23 Ocean Avenue (2016-150) and 1945 Congress (2016-075)

Jeff Tarling <jst@portlandmaine.gov>
To: Helen Donaldson <hcd@portlandmaine.gov>

Tue, Jul 12, 2016 at 9:27 AM

8 WOOD GUARDRAIL
NOT TO SCALE

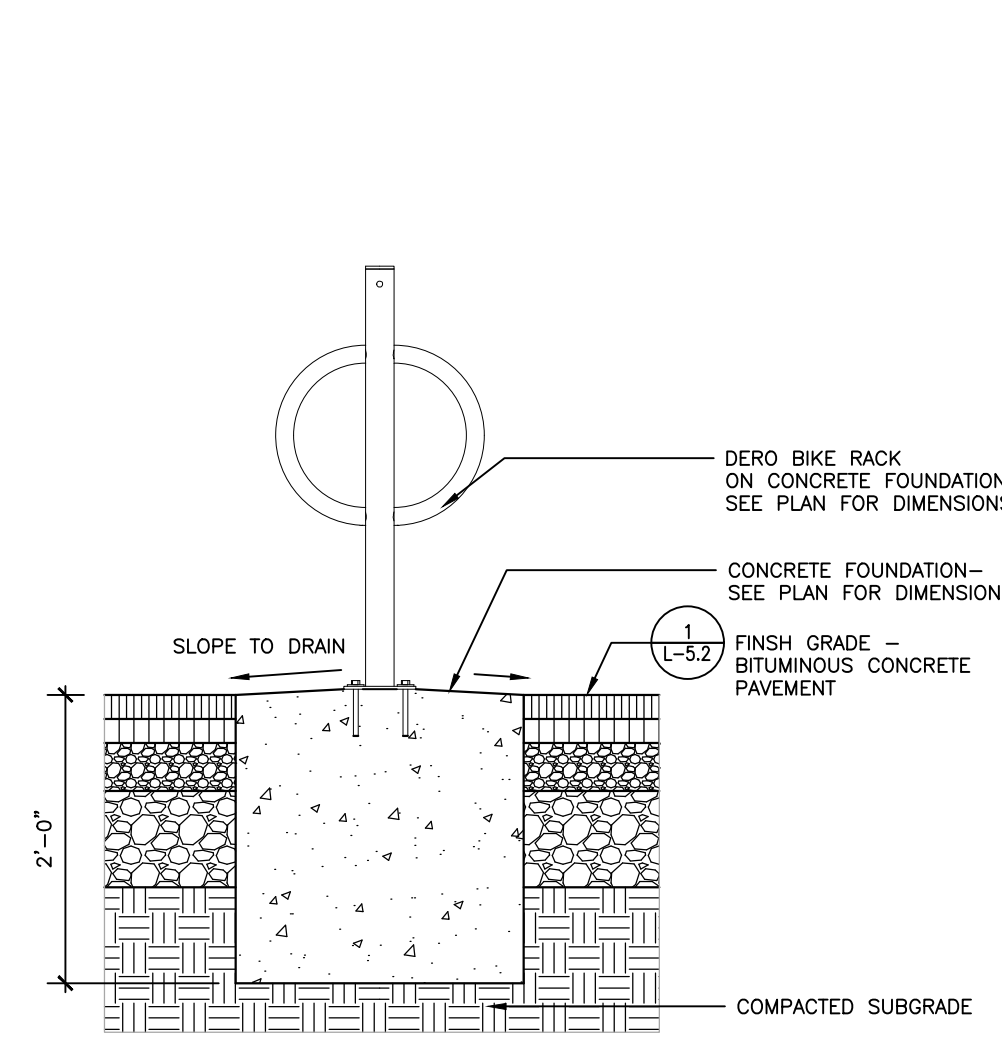
Thus we would like to see 'set-back' tree planting in available spaces. Also parking lot on Hersey Street should have a 4' buffer with plant material at back of sidewalk. A smaller 3' or 2' buffer might not make it. Ideally like to see woody shrub planting but could do ornamental grasses. Wood guardrail on the parking lot side is needed to protect this space from vehicles, snow etc. Without protection plant material would likely be damaged. This buffer on the residential side is more important then the more commerical Ocean Avenue side. Add a couple of trees on the parking lot edge to buffer parking lot from next door residential use. See photos, (I got creative with the pics !)

4 TREE IN LAWN OR ESPLANADE
SCALE: 1/4"=1'-0"

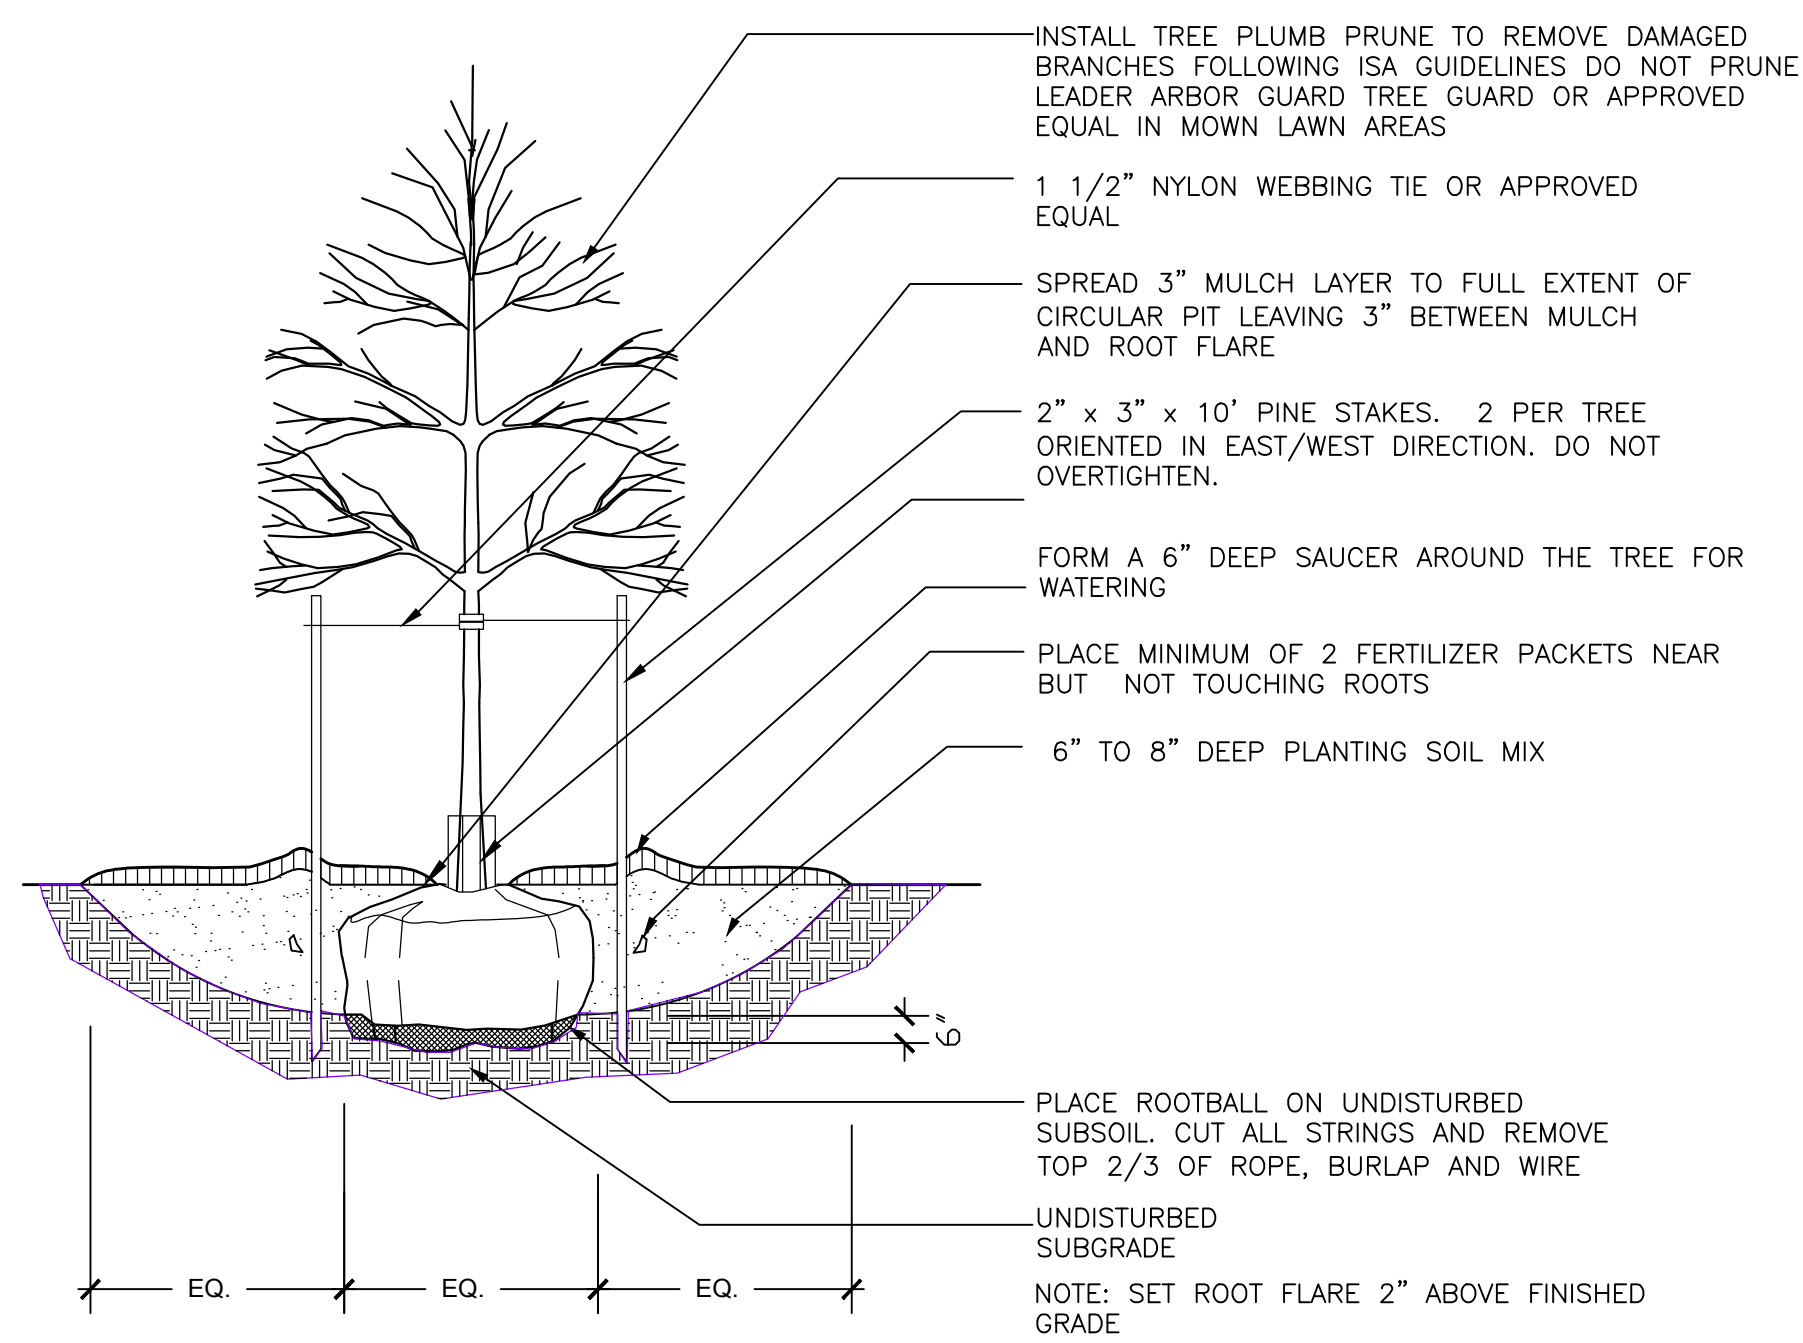
The existing esplanade width is problematic - just too narrow to support Street-trees on both sides, Ocean & Hersey Street. I checked the entire length of Ocean Avenue and no existing street trees, also this is a busy truck / commercial vehicle route and tree canopy even on an upright tree would unlikely to survive. Snow storage in winter along with deicing salts, this sidewalk route is on our priority school walk route and we plow so we need as much space as possible.
